Consultation Response from KC, Lead Local Flood Authority
2025/93057 Land off, Hermitage Park, Lepton, Huddersfield, HD8 0JU
Discharge of details reserved by conditions 27 (BEMP) , 28 (swale), 29 (surface water) and 30 (storm modelling, flood routeing) of previous permission 2025/90105 for variation of conditions 6 (PROW), 9 (boundary treatment), 38 (bin collection), 40 (car parking) and 41 (access) of previous outline permission 2022/91735 (with access and layout) for erection of 80 dwellings and associated works
Date Responded: 8th May 2026 Responding Officer: Paul Farndale Responding Ref: 3

Drawing Title: **PLOT 7 AND 8 EXCEEDANCE FLOW ROUTING**

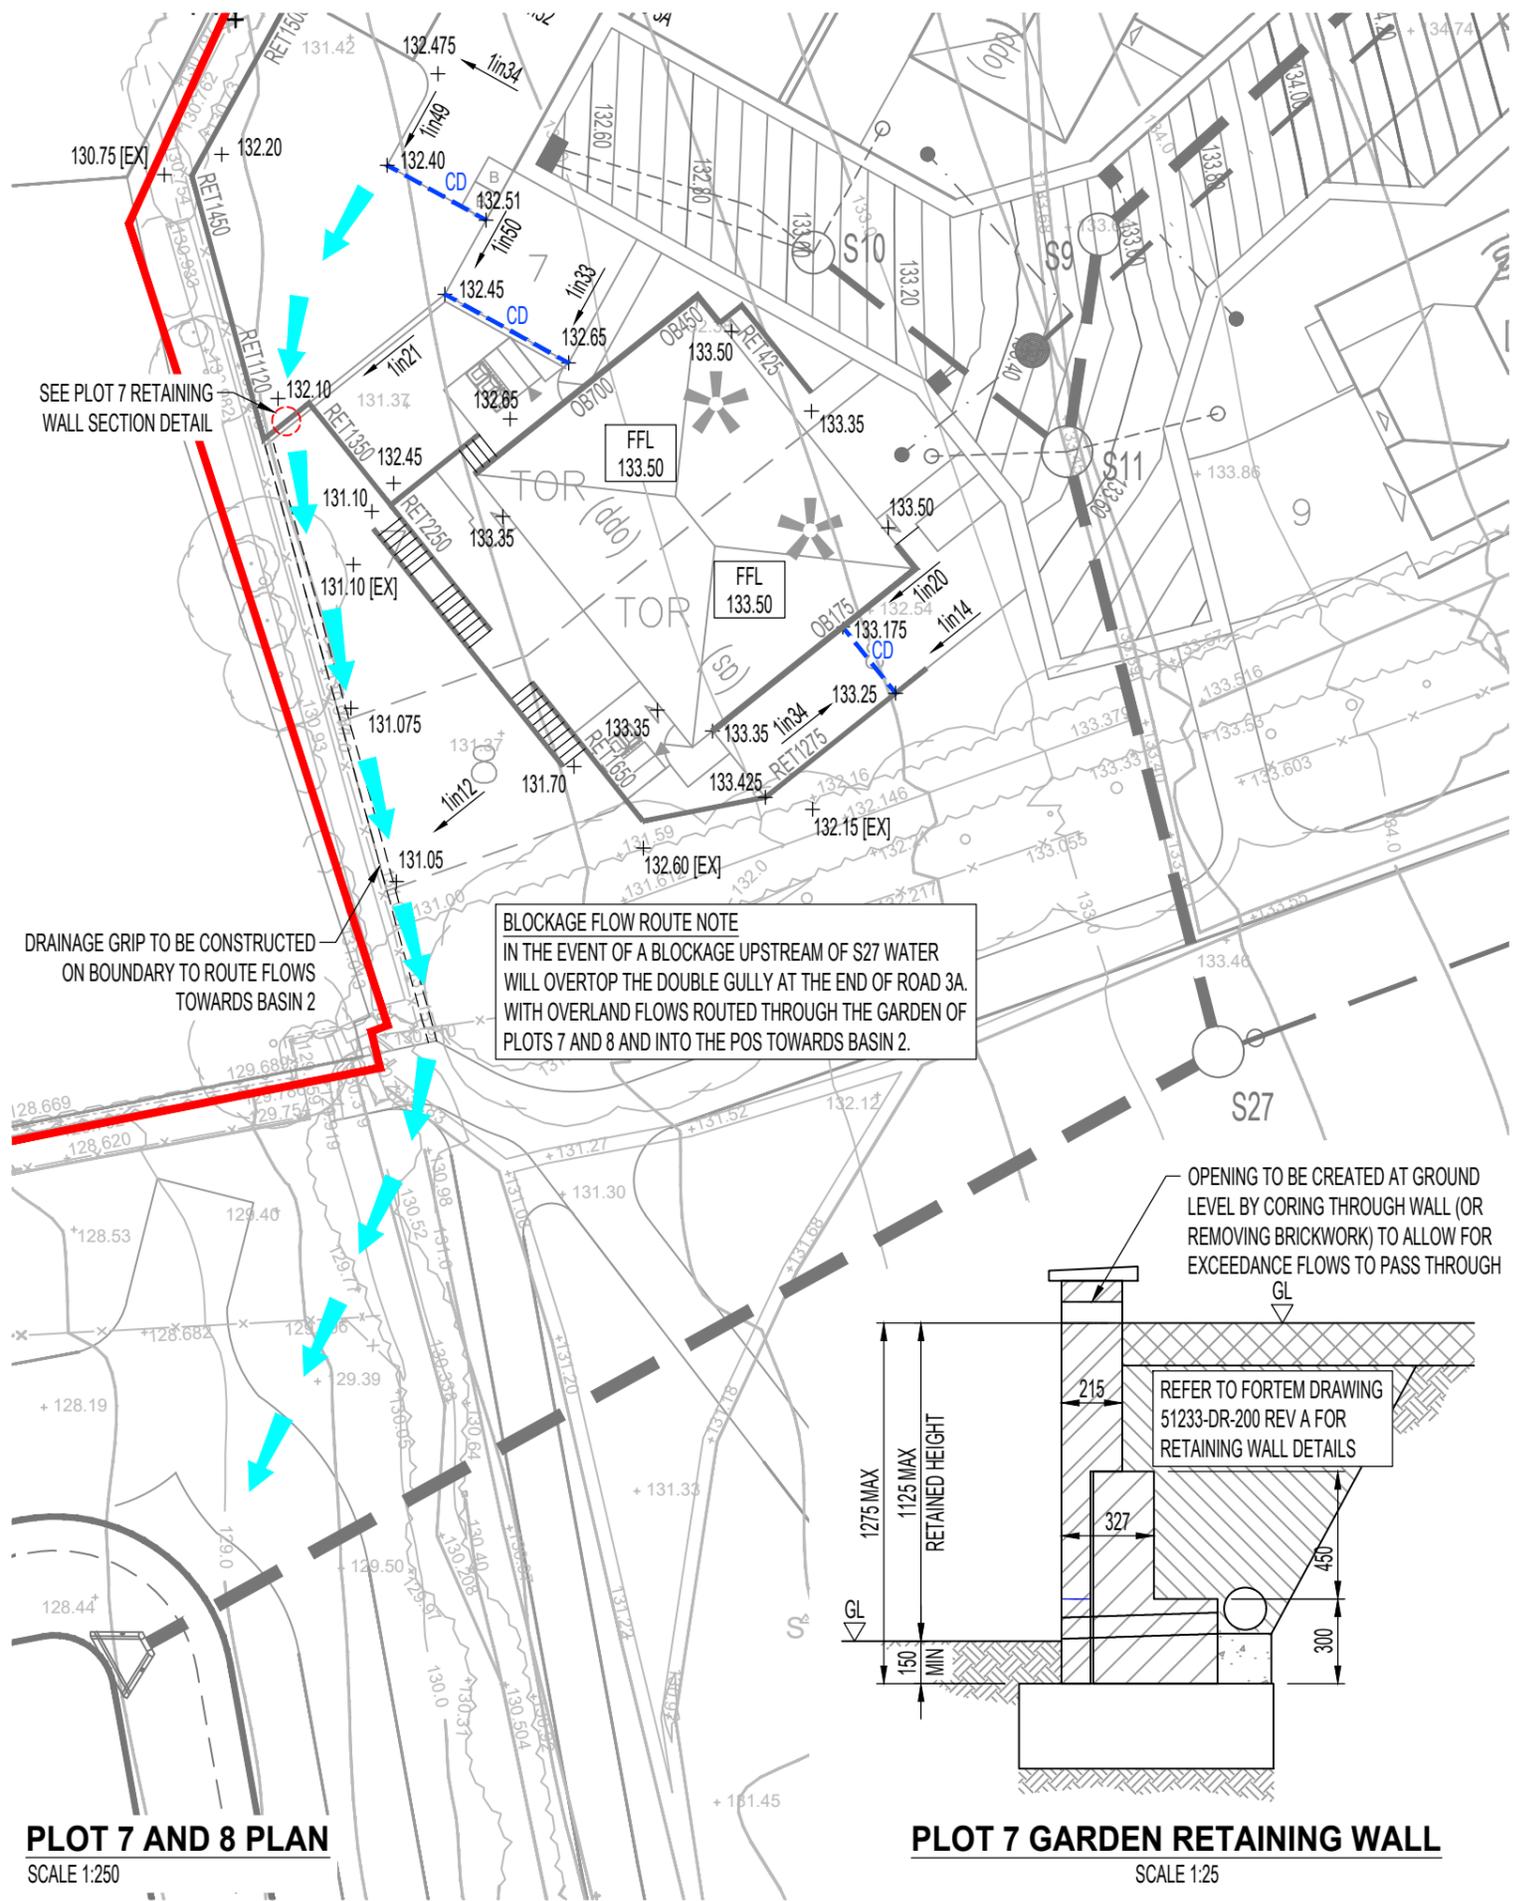
PLOT 7 AND 8 EXCEEDANCE FLOW ROUTING - 1223 - 002 Rev A completes the evidence that flood routing has been accounted for in the layout.

We recommend that this condition can be discharged.
